INTERNAL MEMORANDUM

FROM: Highway Development Control **DATE:** 03/05/19
 Tim Robinson, ext 3536

Planning Application Ref: 19/00333/FULL Land to the North of Castle Street and South East of Waterhouse Lane, Hull.
Highway Authority response to Consultation

**Figure 4: Primary Pedestrian Routes**

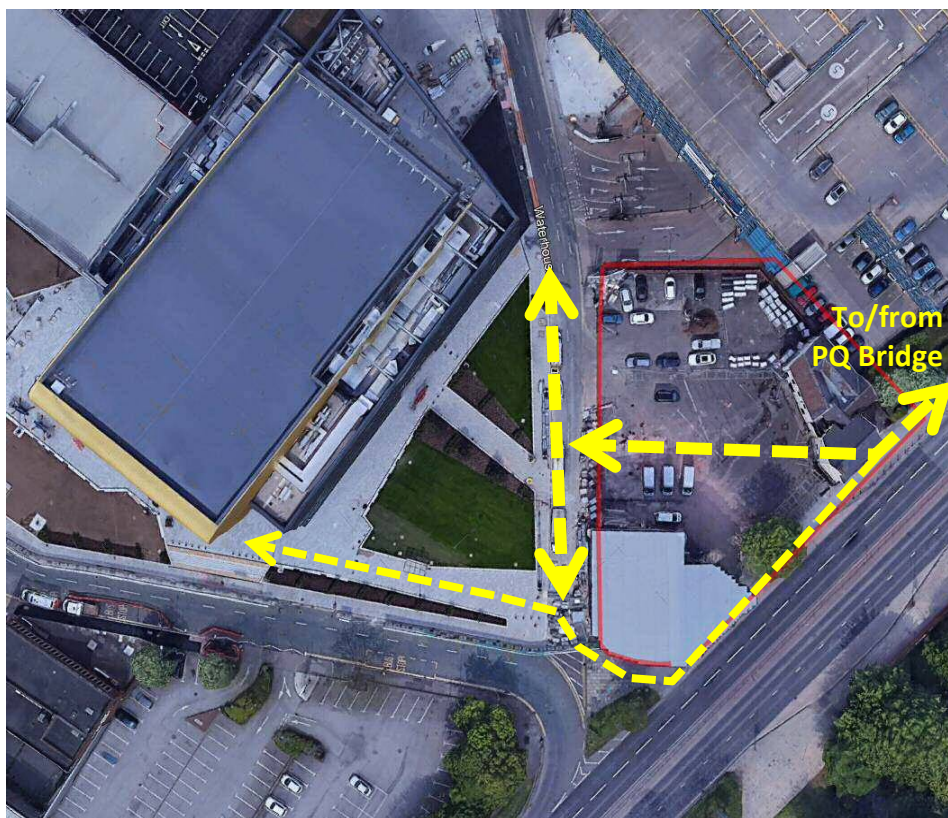
The development creates a courtyard and a through route for pedestrians (and cyclists?) to the Marina / Princess Quay Bridge from the City Centre. This route is expected to be very busy at peak times when the Venue is hosting events during the summer as people walk to and from the Marina.

Concerns are raised over the footway that runs parallel to the A63 in terms of its width as pedestrians walk to and from the Marina via the development.

It is noted there is land directly in front of Princess Quay that could be used to create a wider pedestrian footpath that segregates pedestrians from high speed traffic as they make their way to and from the Marina.

Whilst it is acknowledged that this land is outside the redline boundary of the application, further discussions are requested in order to potentially include this land into a more pedestrian friendly route through the development towards the Marina.
